Our ref: OUT25/8157

Subject: Hillview Hard Rock Quarry (SSD-70557215) – Environmental Impact Statement

### Detailed advice to DPHI Planning & Assessment regarding the Hillview Hard Rock Quarry (SSD-70557215) – EIS

**LEGEND**

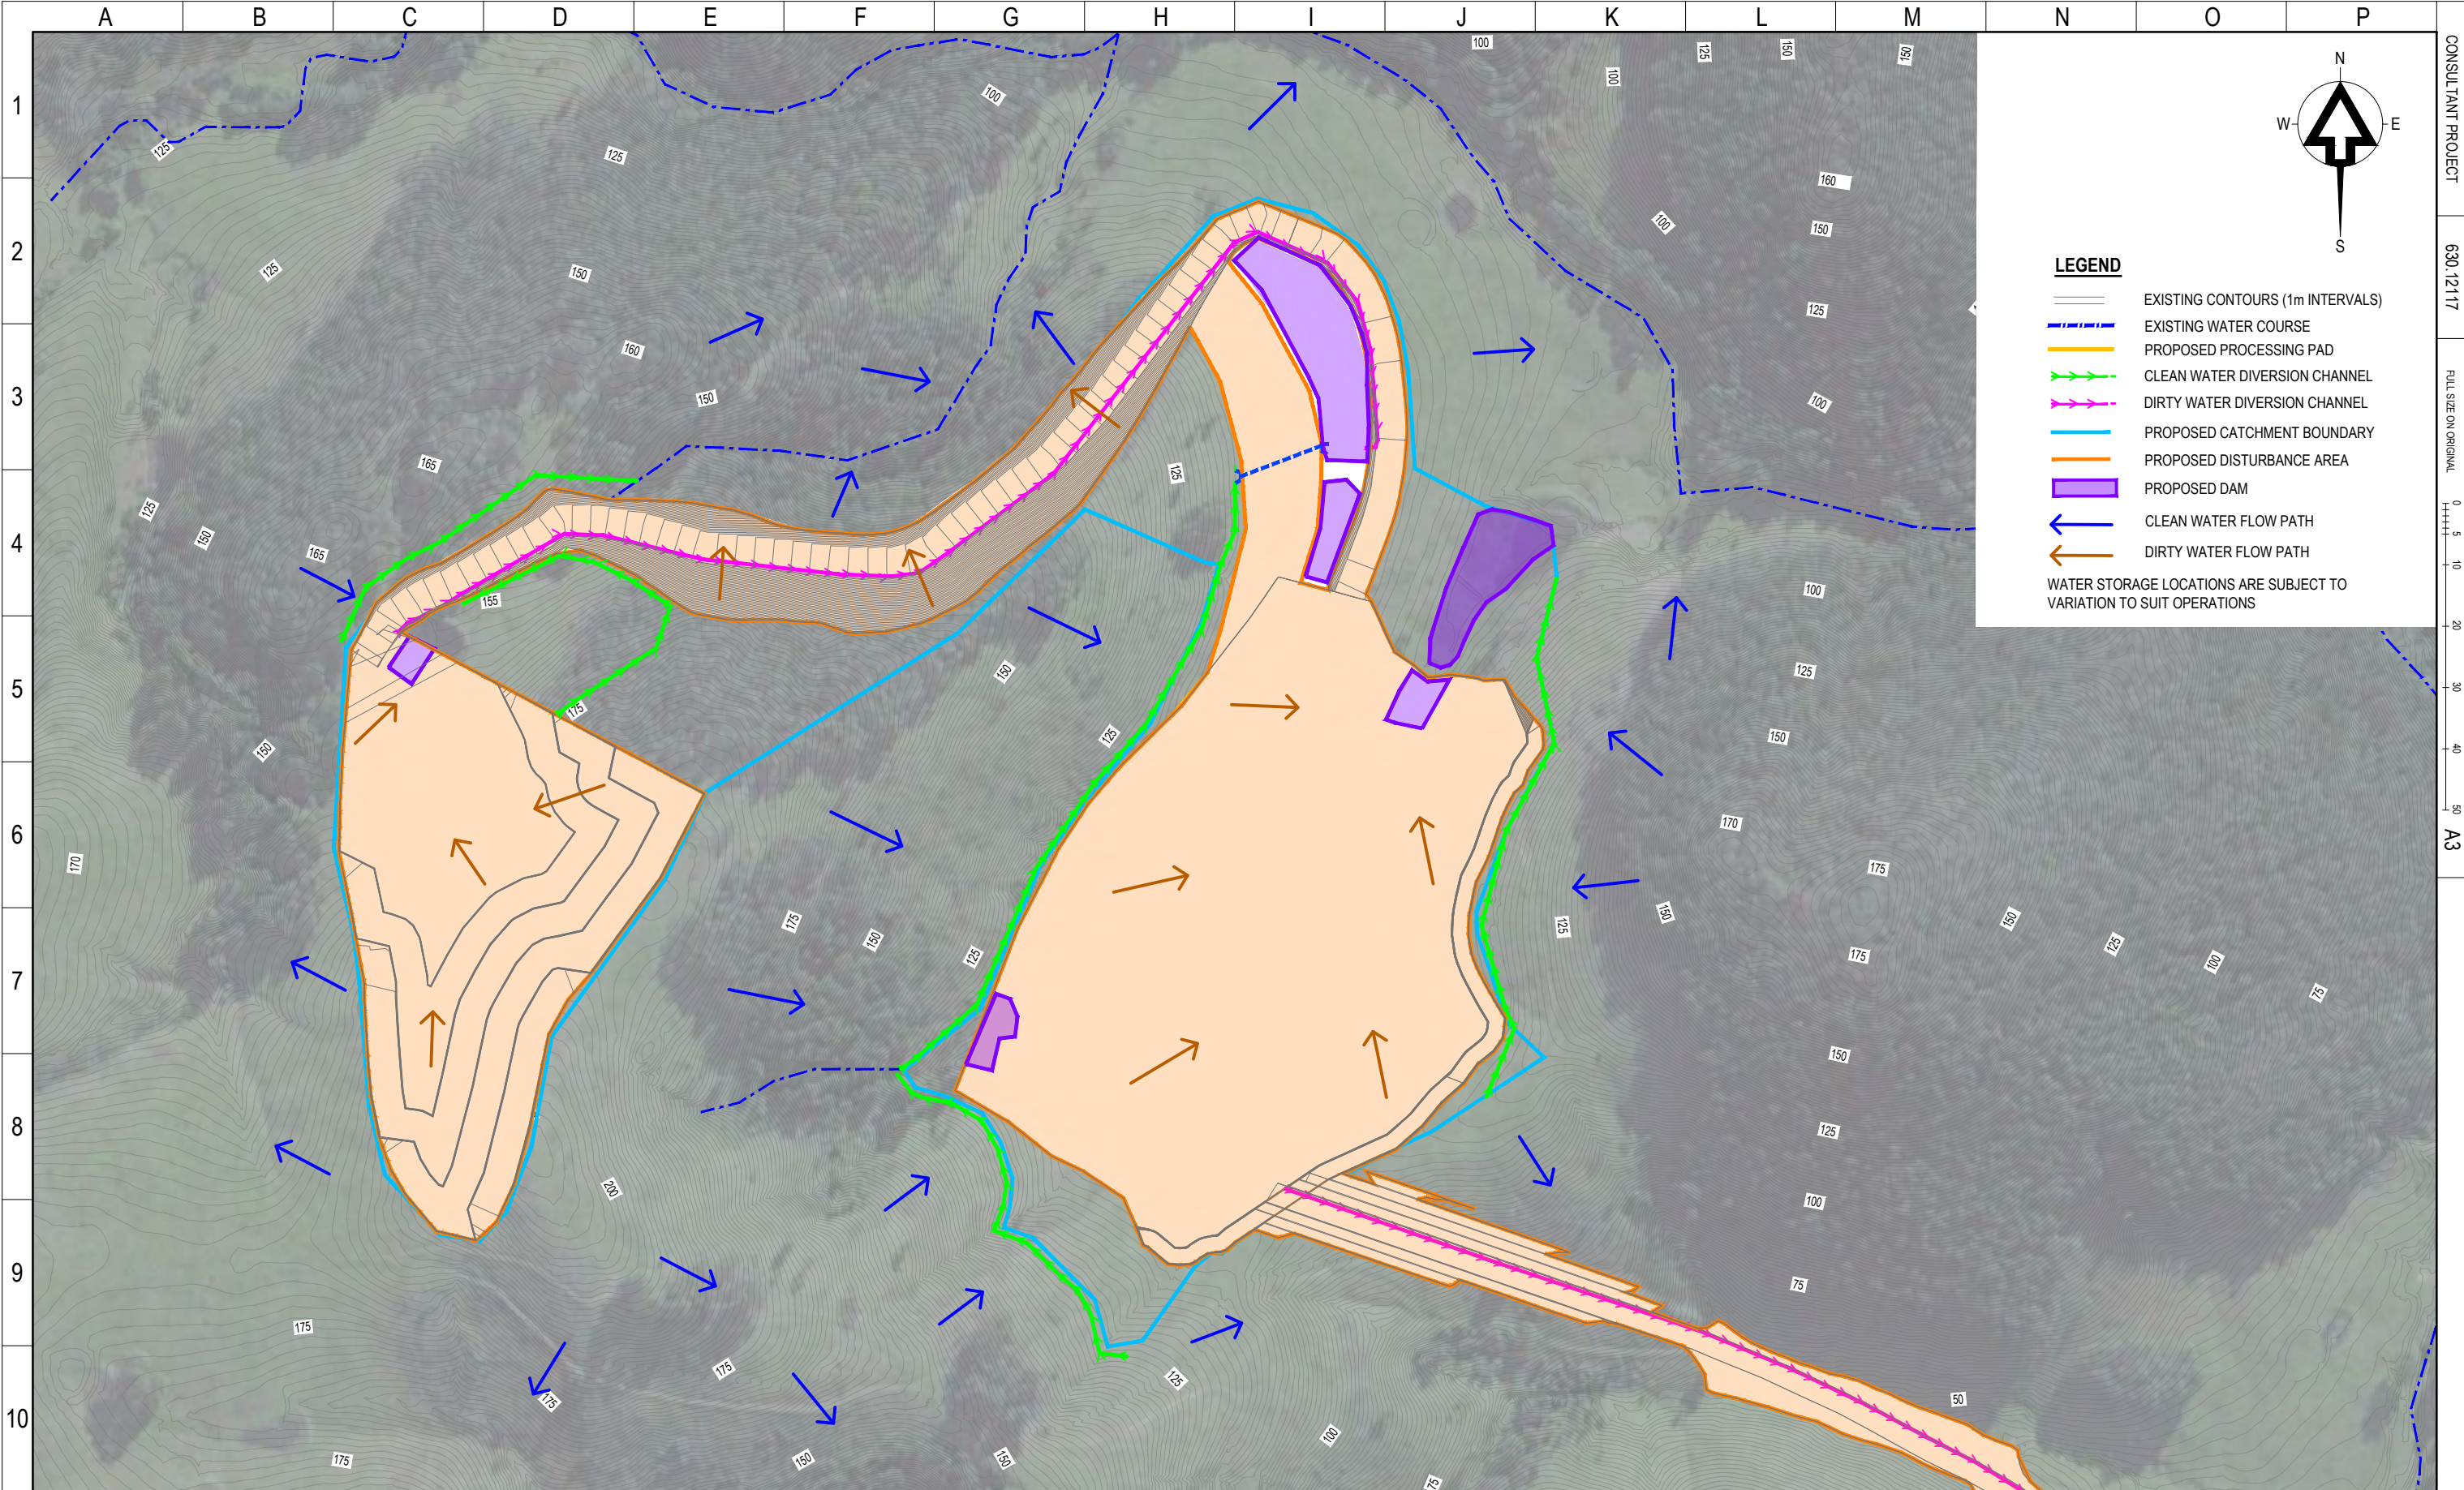
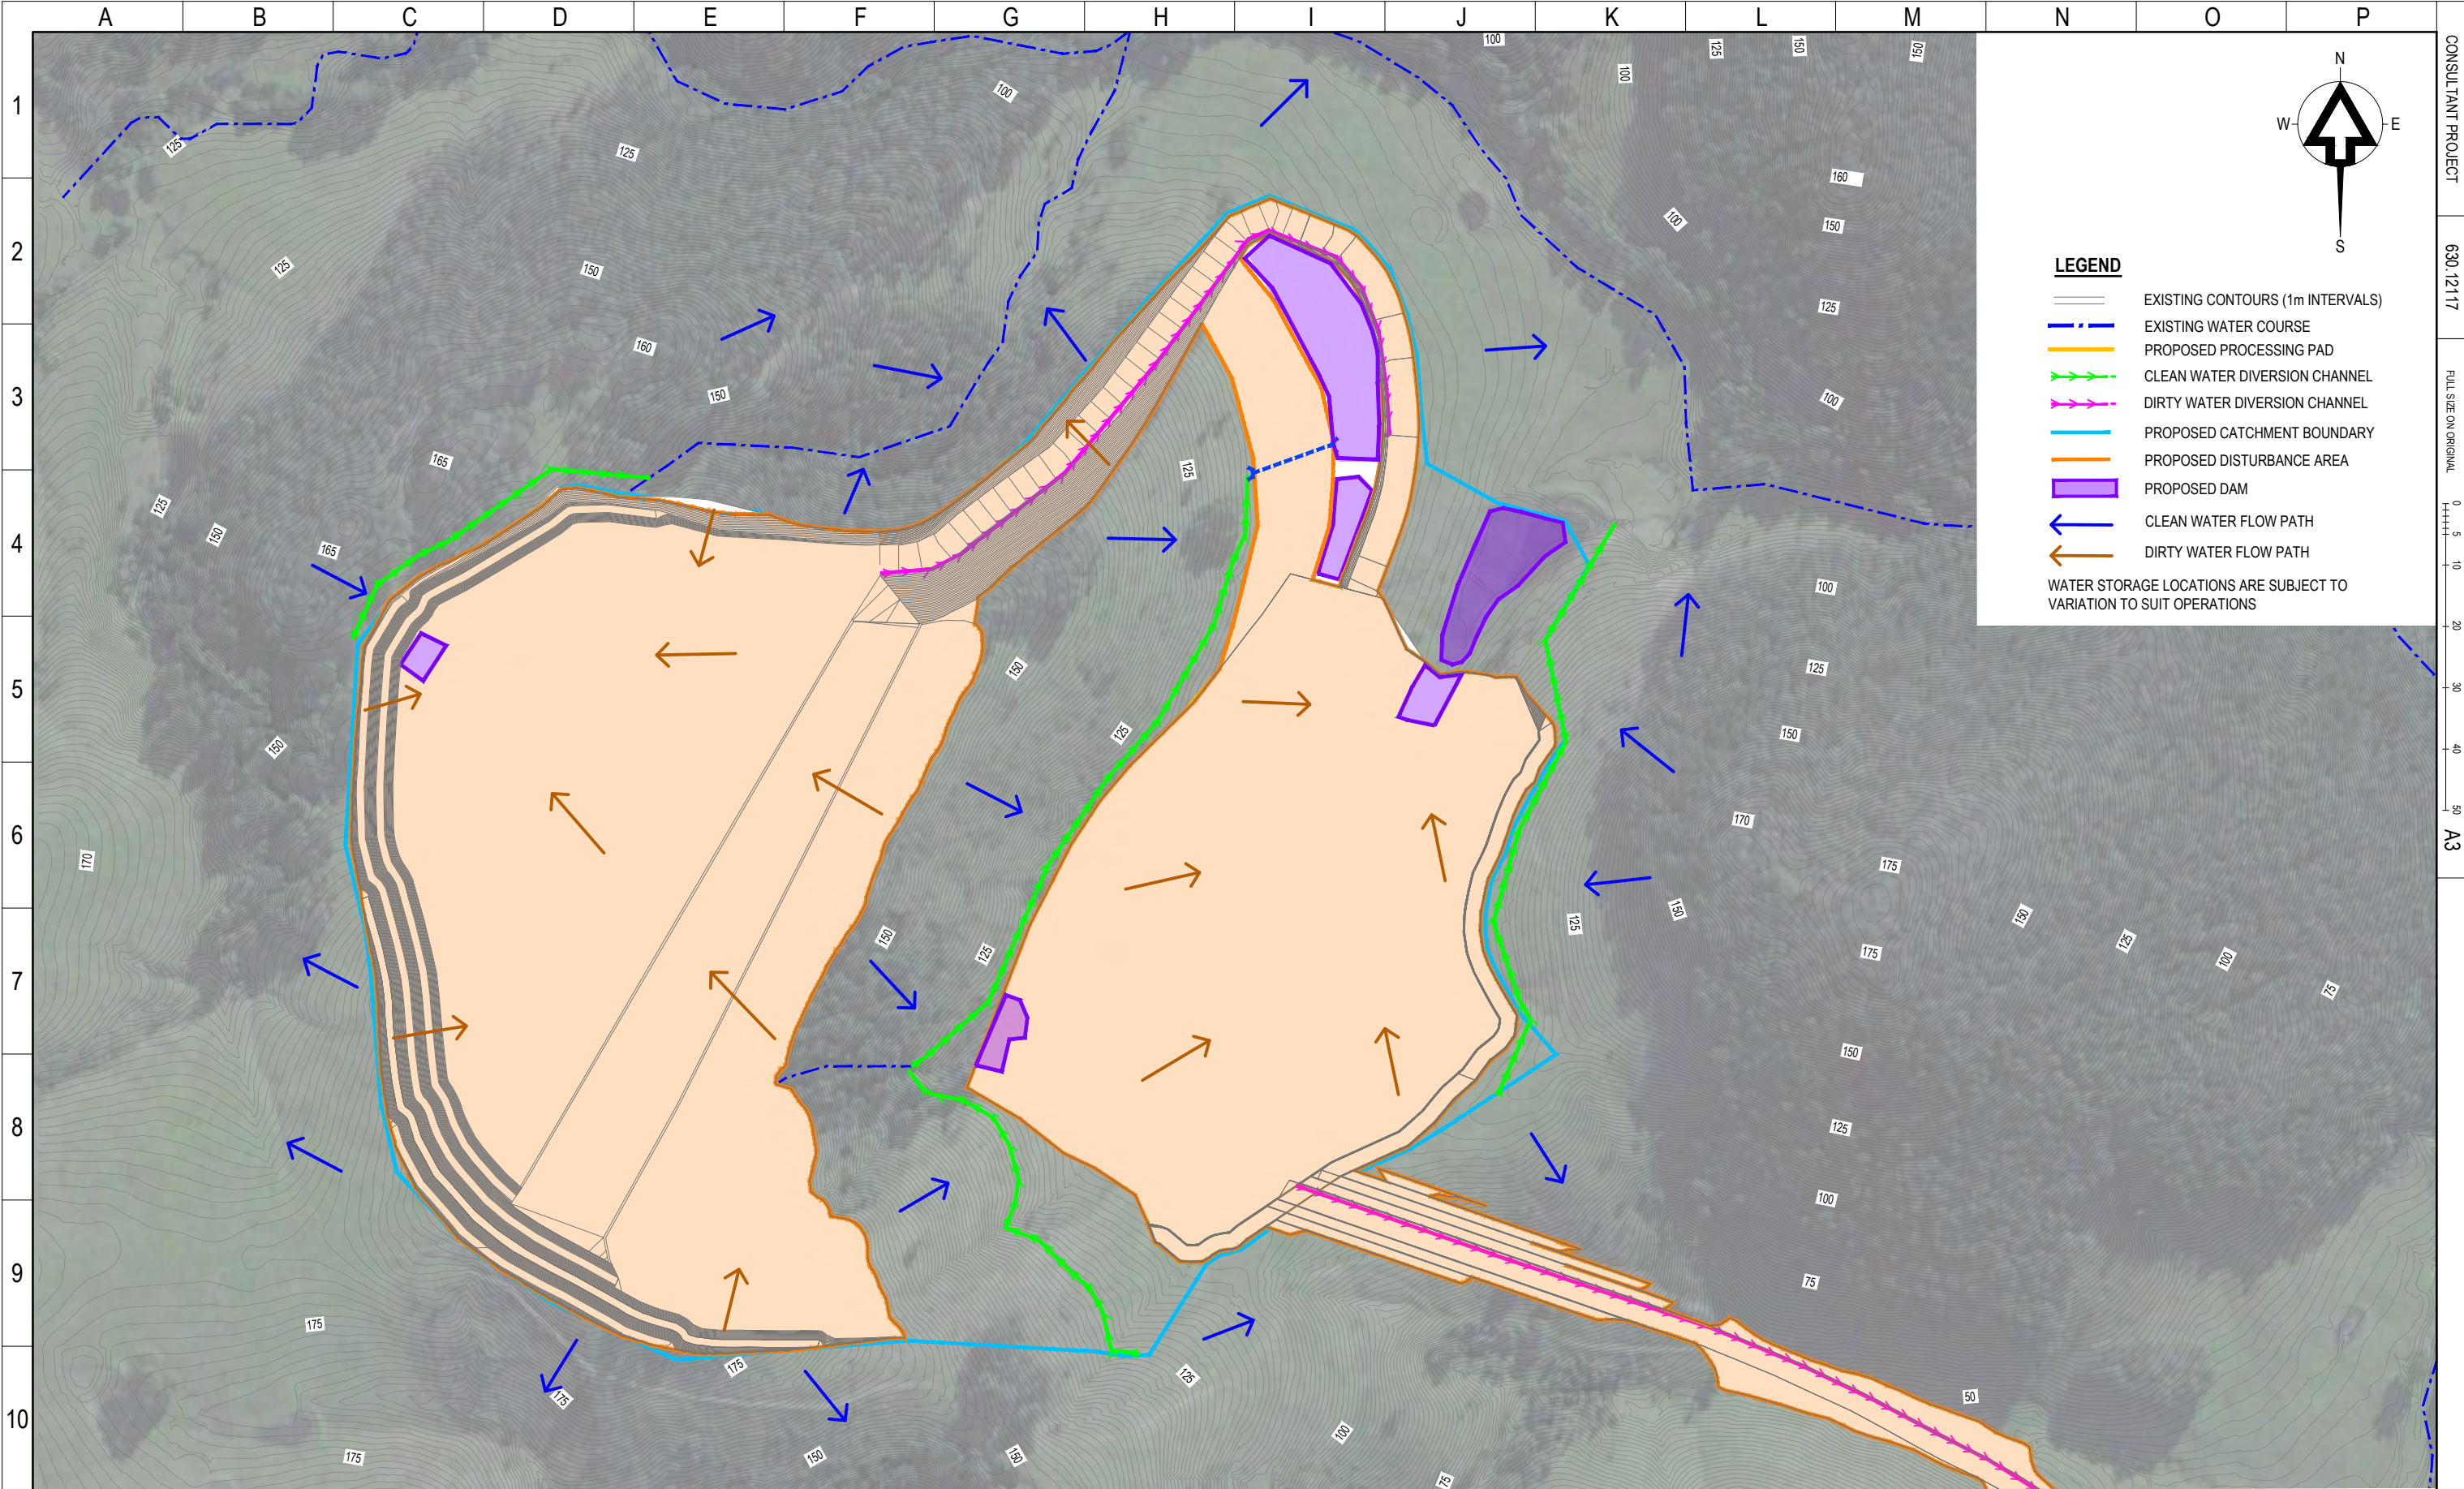
The proposal includes several dams/basins which need to be considered against the water licensing framework. This should consider the harvestable rights capacity, exclusions under Schedule 1 of the *Water Management (General) Regulation 2018* or the requirement to obtain entitlement. Figures 24-29 and 49 of the Surface Water Assessment show that an existing 'Farm Dam' is proposed to be converted to a sediment dam at the outlet of the quarry. This dam is on a third order stream so would not meet the definition of an excluded work under Schedule 1 of the WM (General) Regulation as it is not located on a minor stream.

Dams on third order watercourses do not meet the Departments Guidelines for Controlled Activities on Waterfront Land – Riparian Corridors. It is generally requested that water quality treatment occurs offline.

The Department of Planning, Housing and Infrastructure request the proponent to review the proposed surface water structures to confirm the requirement for water licensing or where an exemption may apply. This is to include a review against:

- The excluded work provisions under Schedule 1(4) of the Water Management (General) Regulation 2018. Further information is available at: [https://water.dpie.nsw.gov.au/\\_data/assets/pdf\\_file/0008/554444/excluded-work-exemption-fact-sheet.pdf](https://water.dpie.nsw.gov.au/_data/assets/pdf_file/0008/554444/excluded-work-exemption-fact-sheet.pdf)
- Maximum harvestable rights dam capacity where dams are located on minor streams and capture runoff.
- The requirement for licensed entitlement where the water capture/use is not exempt or excluded, and to demonstrate this can be obtained in the relevant water source.
